From: [REDACTED]
Sent: 23 November 2022 14:51
To: Planning
Subject: Planning application number 3/2022/1030

Reference:- Planning Application 3/2022/1030

1, Moorland Rd, Langho, BB6 8EX.

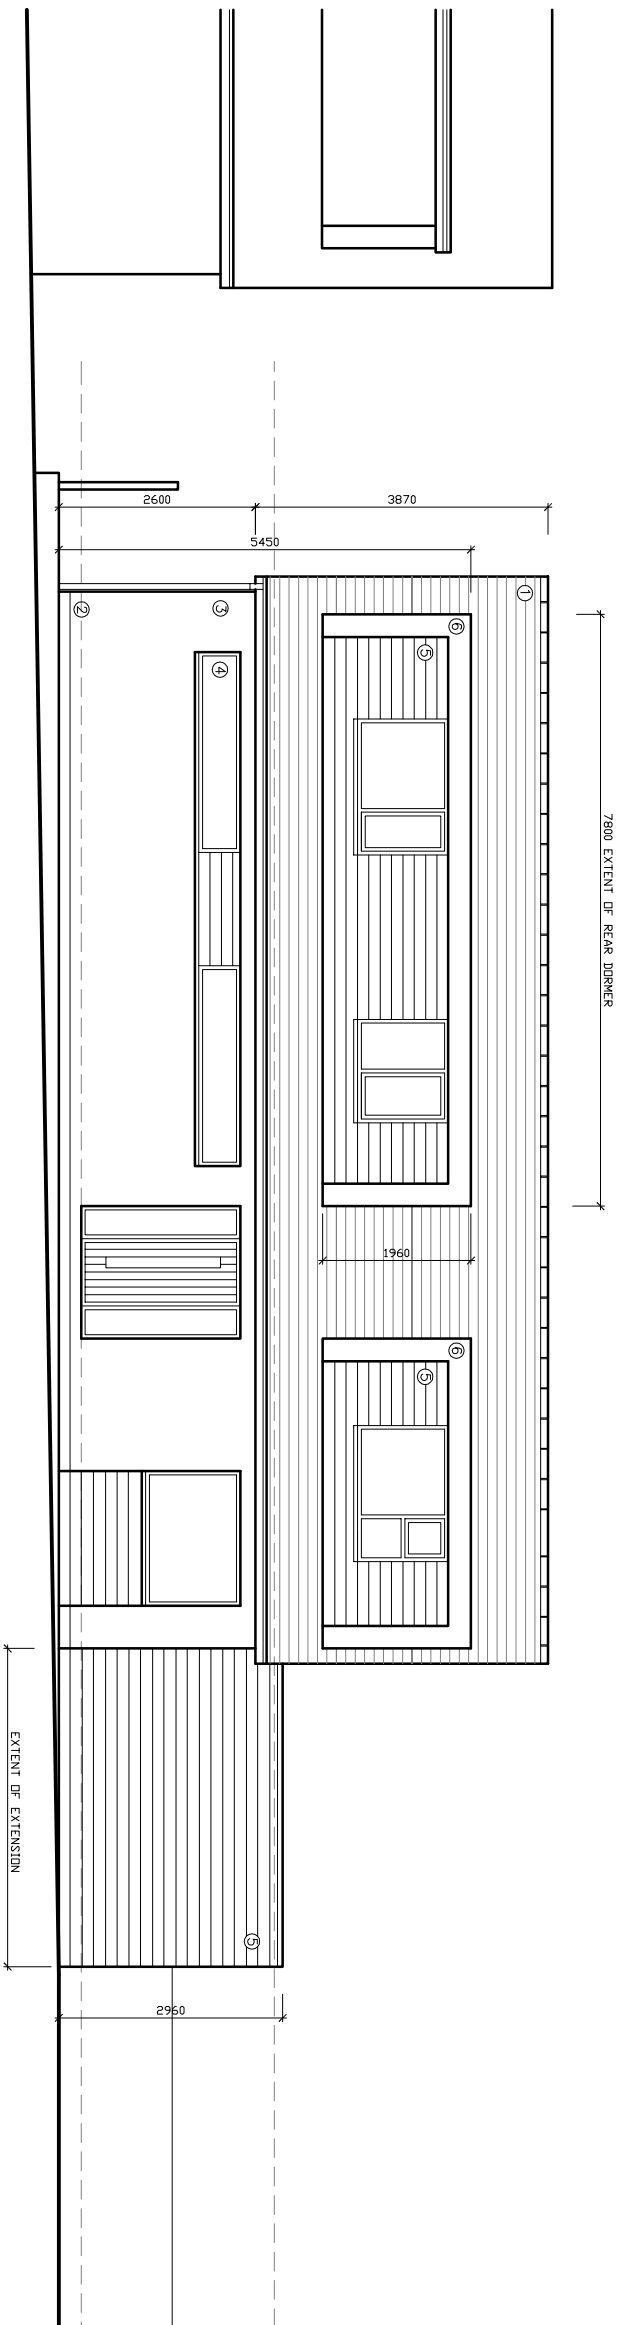
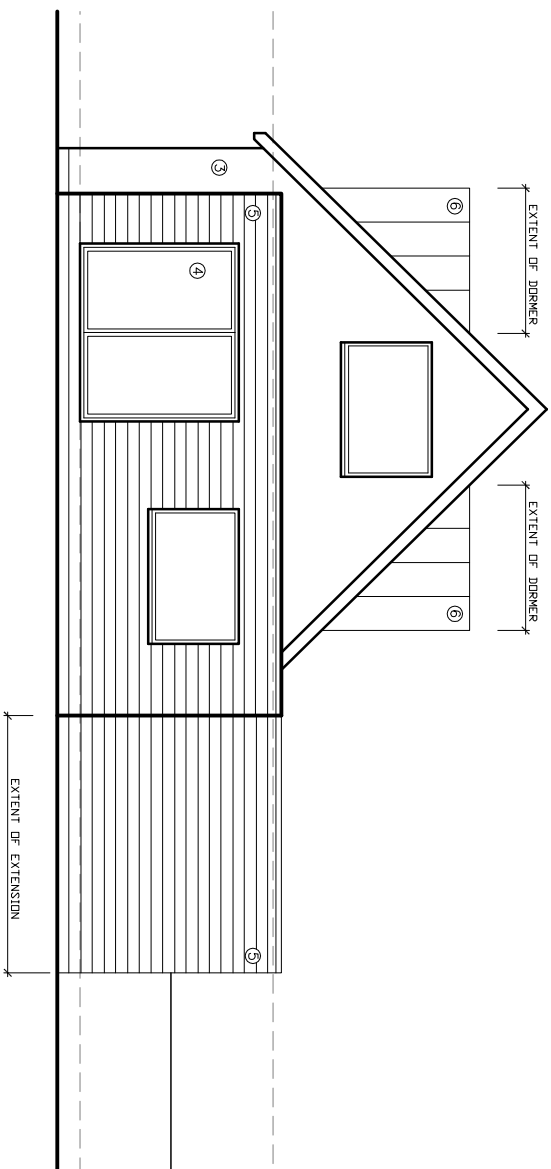
The second is the raising of the roof and the dormer to the rear of the property.

The side of the dormer will be [REDACTED] not very pleasant. This will also obstruct a [REDACTED] through this window.

The plans suggest that the house will be of a very modern style. With zinc/aluminium covering to the sides, front edges and roof of the dormers. Two long narrow windows will be positioned to the front of the house which will look totally out of character with the surrounding houses.

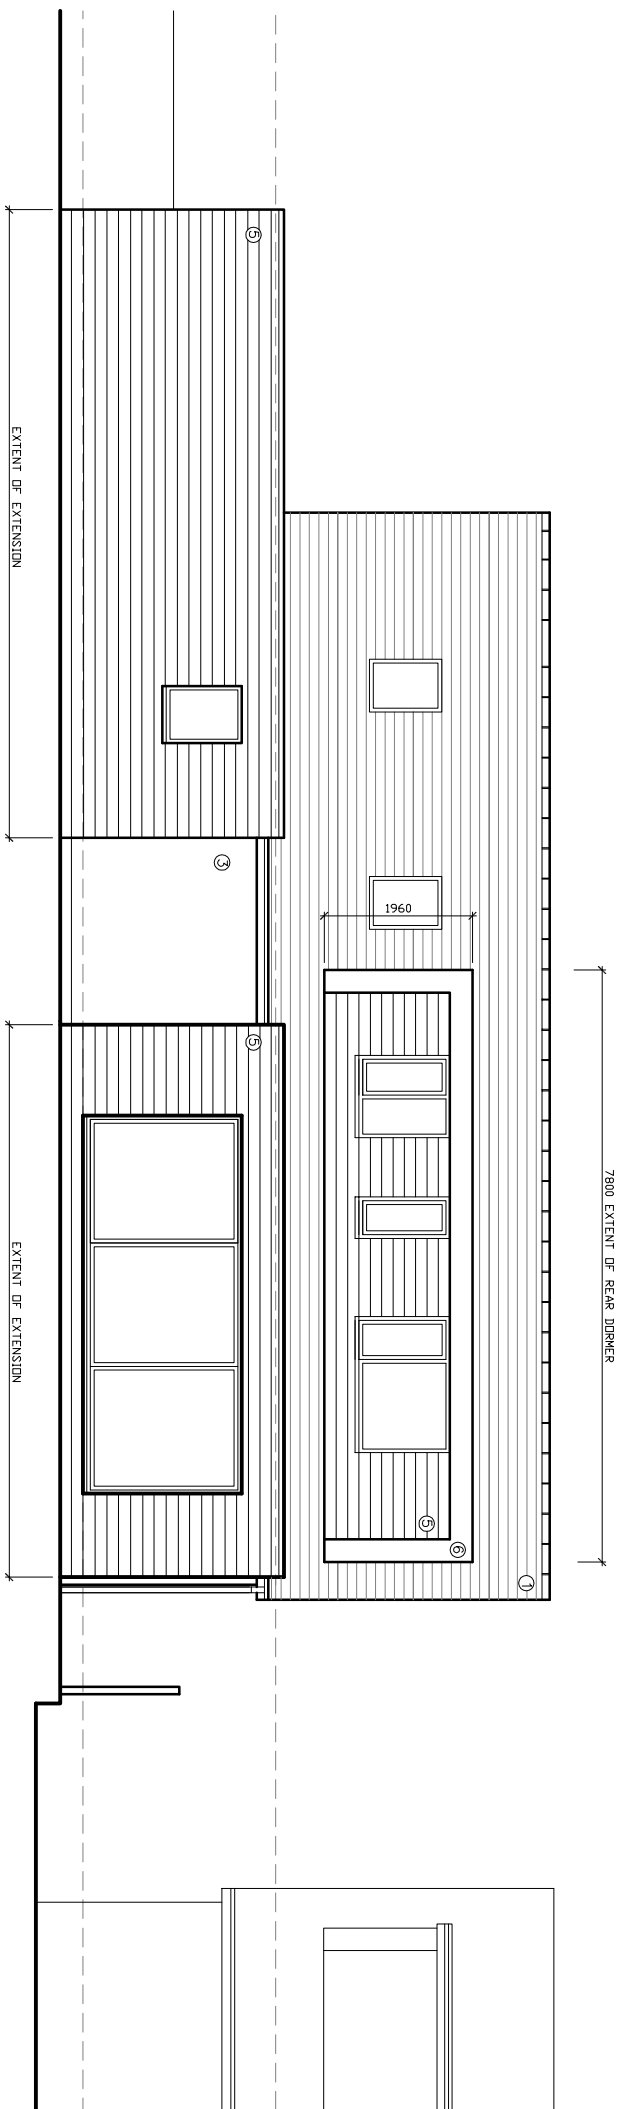
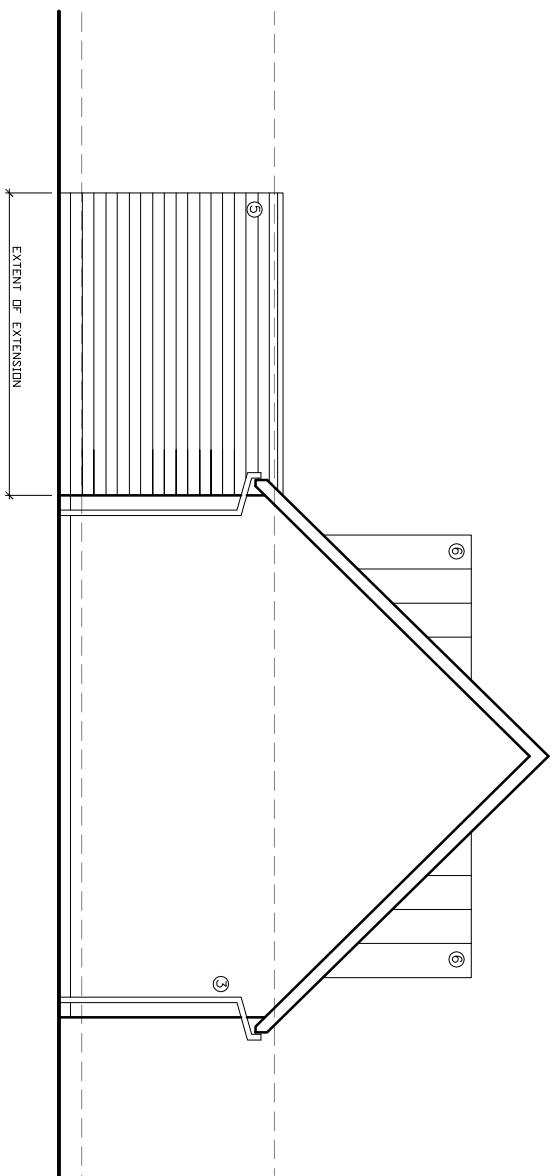
The first is the proposed large extension to the rear with large patio doors. I understand that this is to be the main living area. The property is in a slightly elevated position [REDACTED] and as the extension protrudes so far into the [REDACTED]

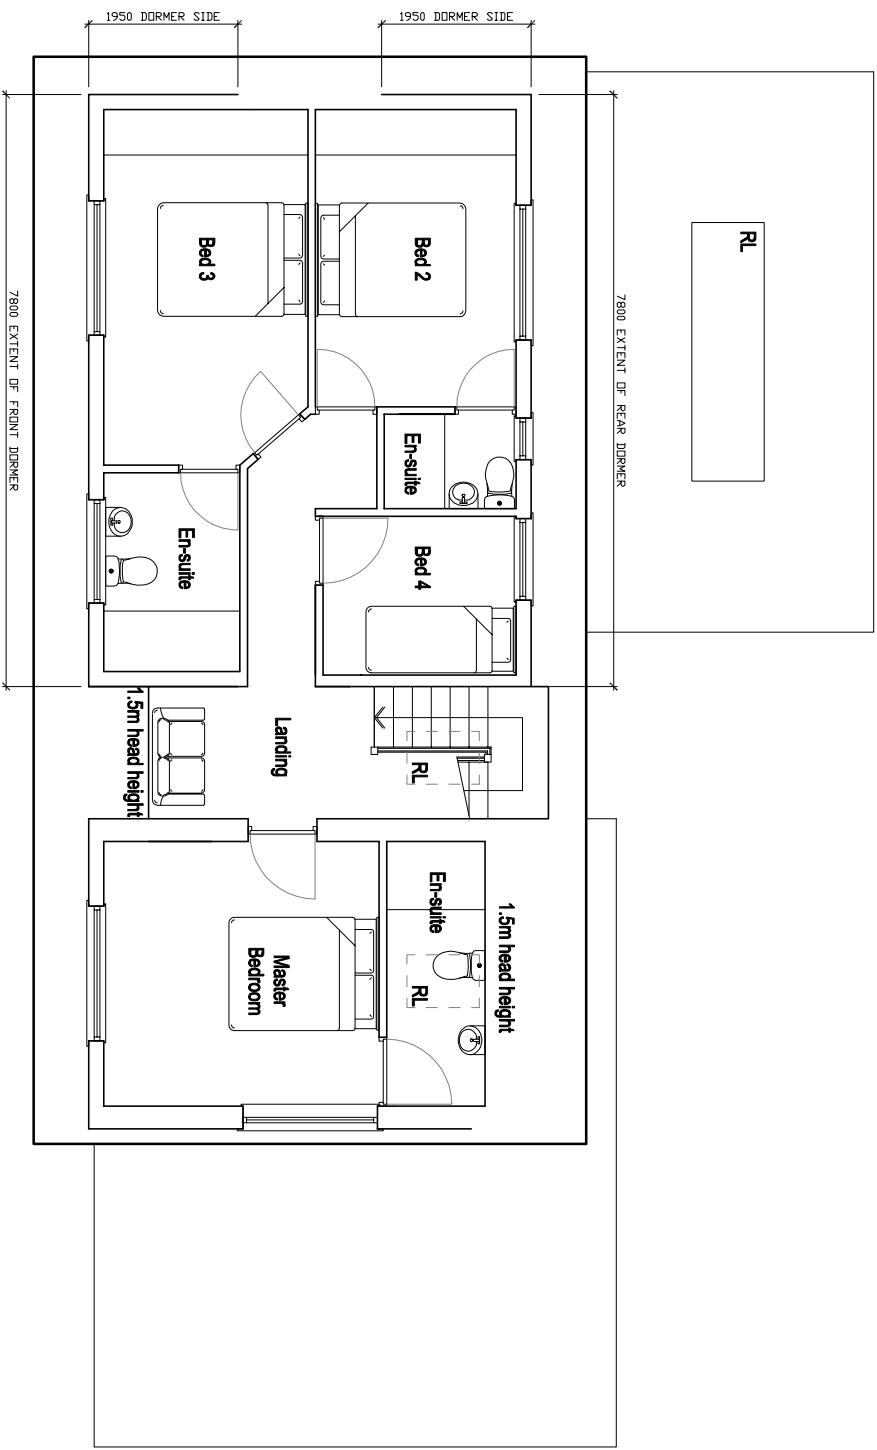
The proposed plans will significantly increase the current footprint of the existing property and alter the look / aesthetics of the outside.
